**DISCOVERY POINT STAGE 6  
BUILDING 6**

**ACCESS REVIEW**

**Morris-Goding Accessibility Consulting**

22<sup>nd</sup> August 2011

Arc
Discovery Point, Wolli Creek
Basement 1 Plan

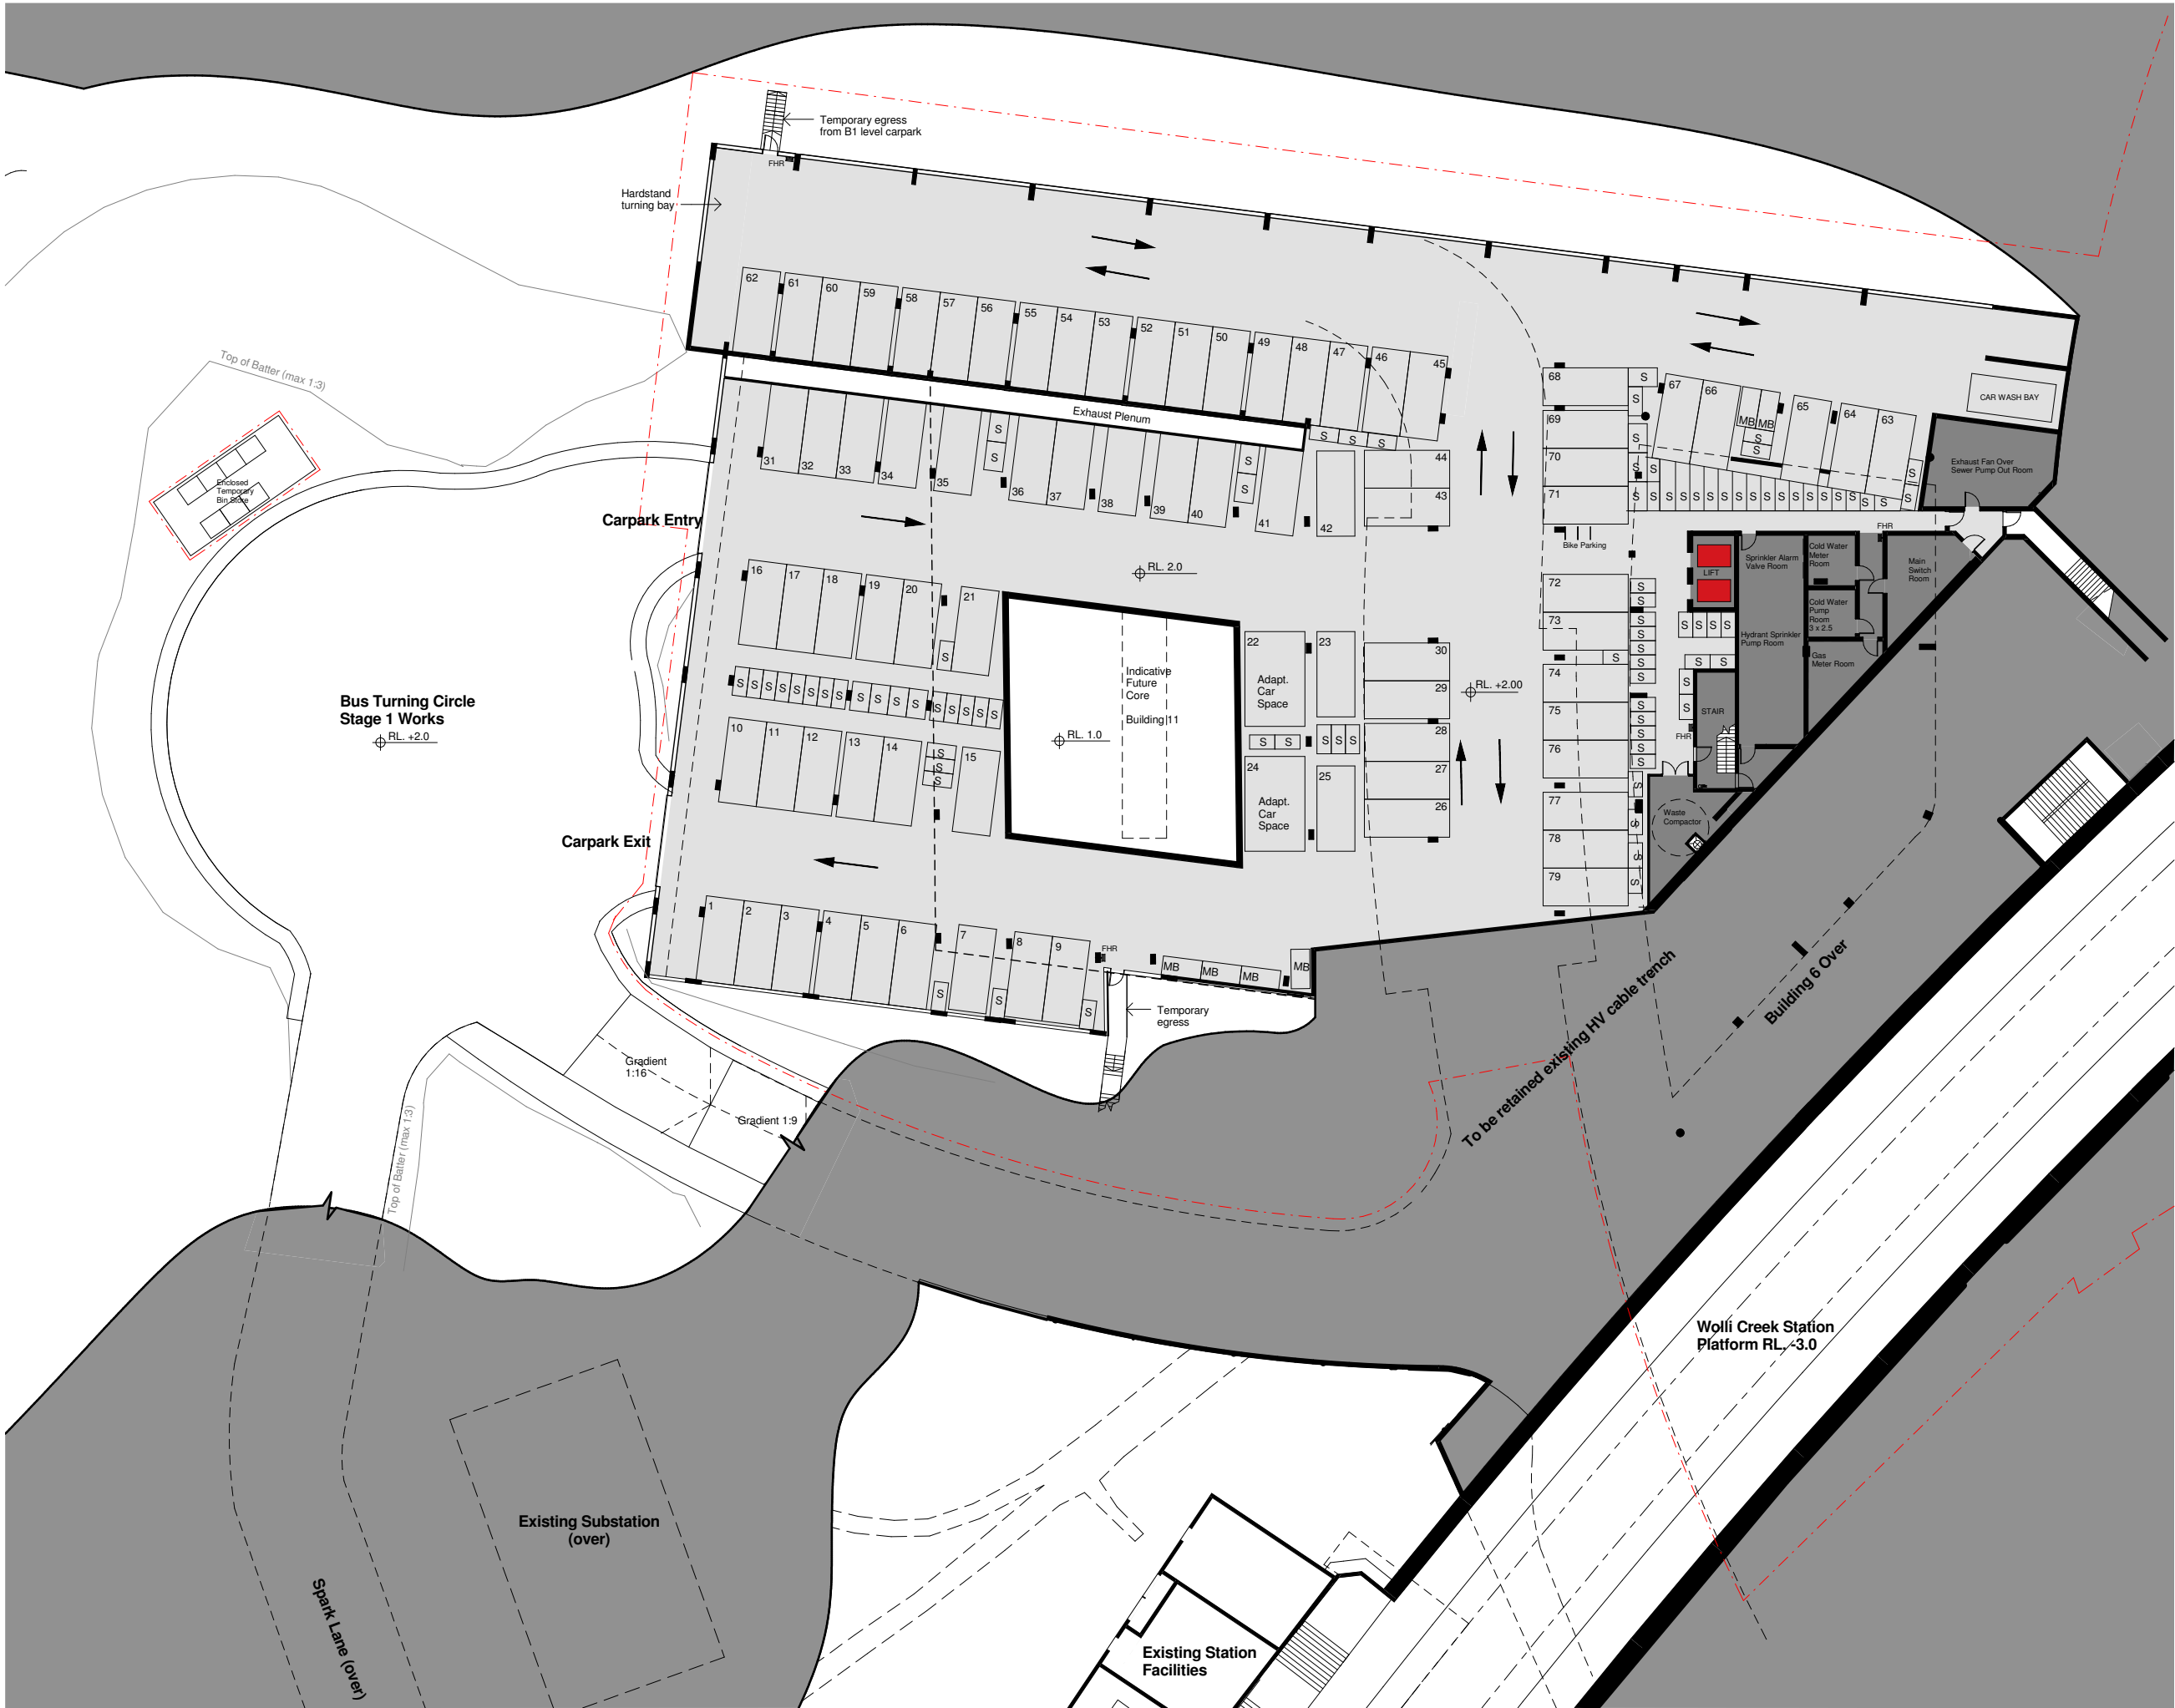
The drawings indicate an approx. total of 79 residential car parking bays including 2 designated car parking bays for the adaptable units with dimensions of 3800mm width x 6000mm length, compliant with AS4299.

The adaptable car bays are located centrally within the car park and access to the lift facilities requires traversing the vehicular driveways.

- (i) Ensure each adaptable car bay provides a height clearance of 2500mm height.
- (ii) The approach to each adaptable car parking bay should not have height clearance of at least 2200mm height.

These recommendations are achievable and will be incorporated at construction certificate stage.

Arc
Discovery Point, Wolli Creek
Ground Floor Plan

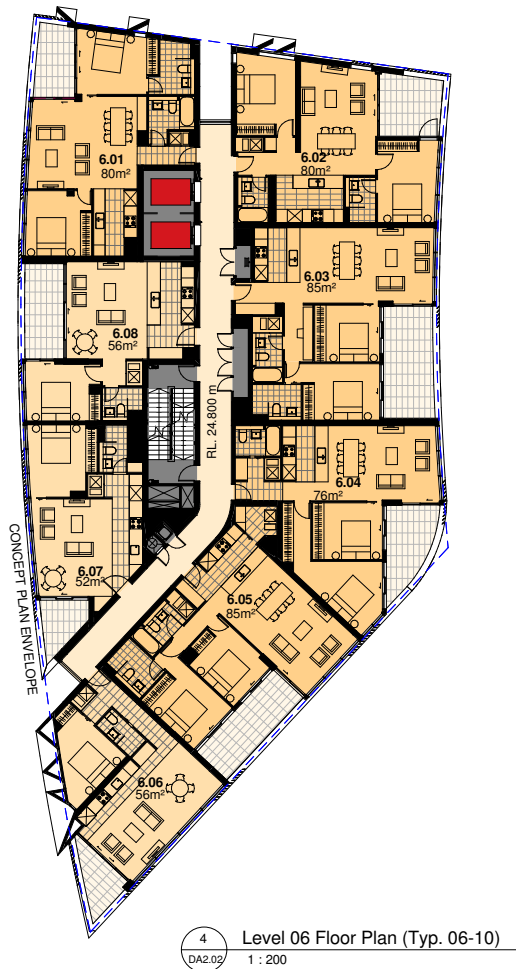
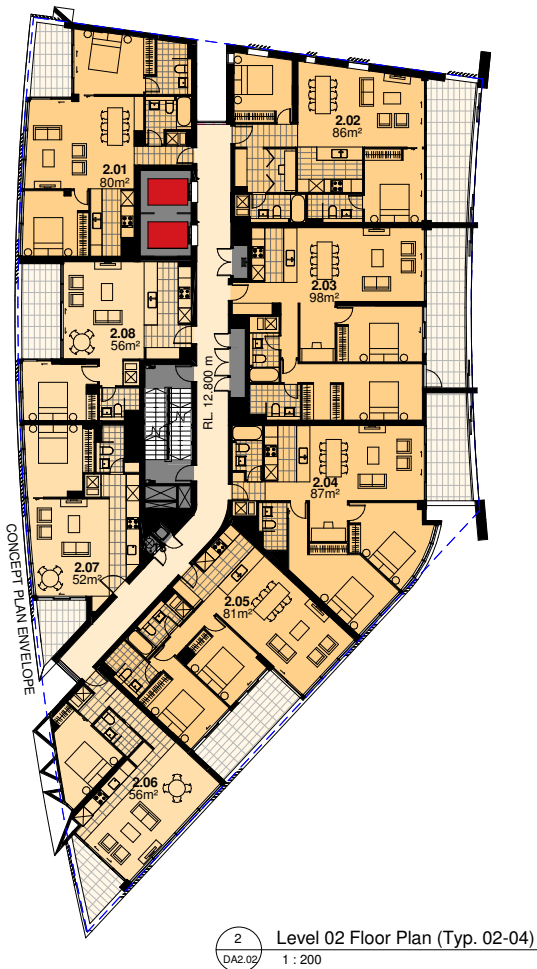
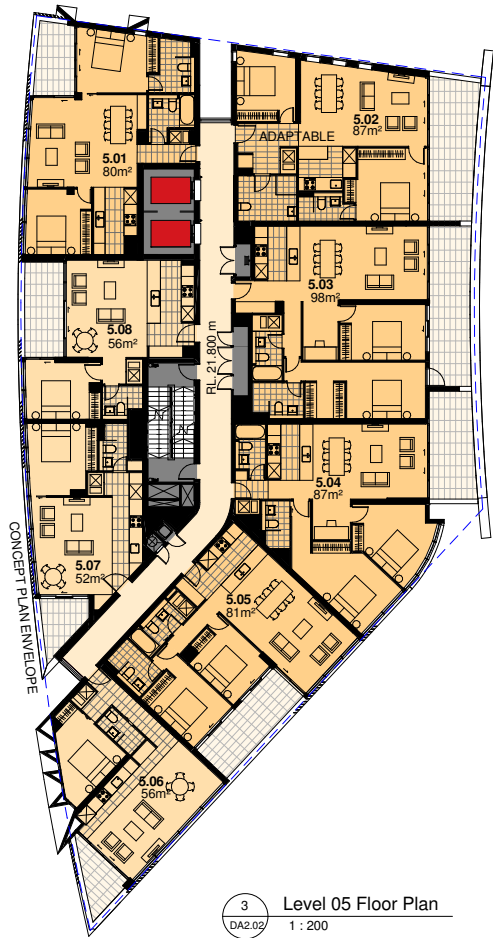
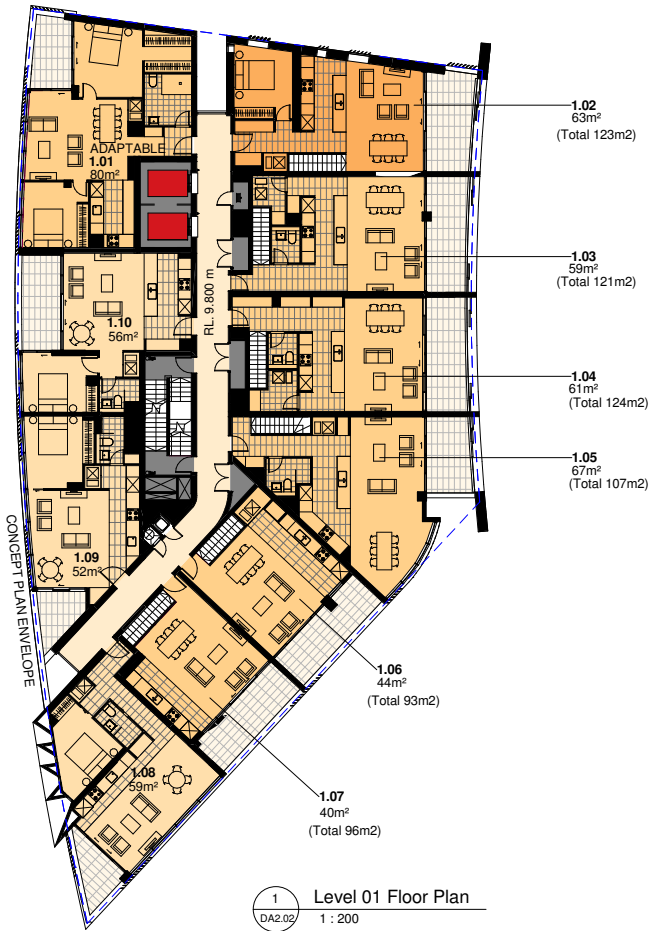
Entry access is via outward opening dual-hinged doors (approx. 1550mm combined width), which requires review for compliance with AS1428.1:2009 and AS4299. The doorway circulation areas on both sides of the entry are compliant with AS1428.1:2009.

- (i) Provide 850mm clear width active leaf doors at main entry in accordance with AS1428.1:2009 and AS4299.
- (ii) Ensure level entry thresholds at entry doorway (5mm max. height variation) in accordance with AS1428.1:2009.
- (iii) Ensure door components are compliant with AS1428.1:2009.

These recommendations are achievable and will be incorporated at construction certificate stage.

Arc
Discovery Point, Wolli Creek
Level 01-10 Floor Plan

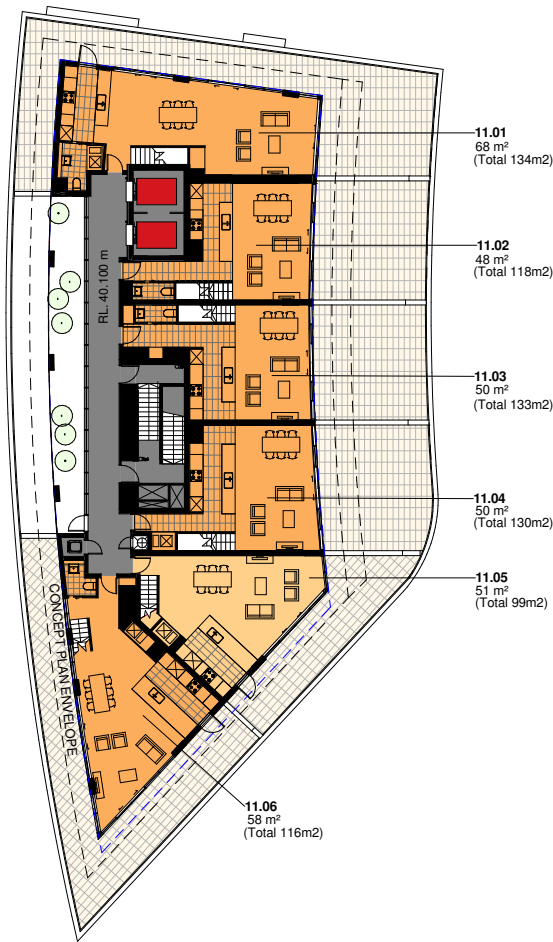
There is a small common-use waste chute and garbage area on each residential floor which is directly accessed via single outward opening doorways (approx. 600mm width) in central corridor. The limited internal area does not allow entry through the door for any potential users with access achieved in a similar way to a cupboard or wardrobe.

- (i) Provide off-set hinges to doors to waste chute and garbage area to increase the potential external circulation area outside the common-use doorways in line with the intent of AS1428.1:2009.

These recommendations are achievable and will be incorporated at construction certificate stage.
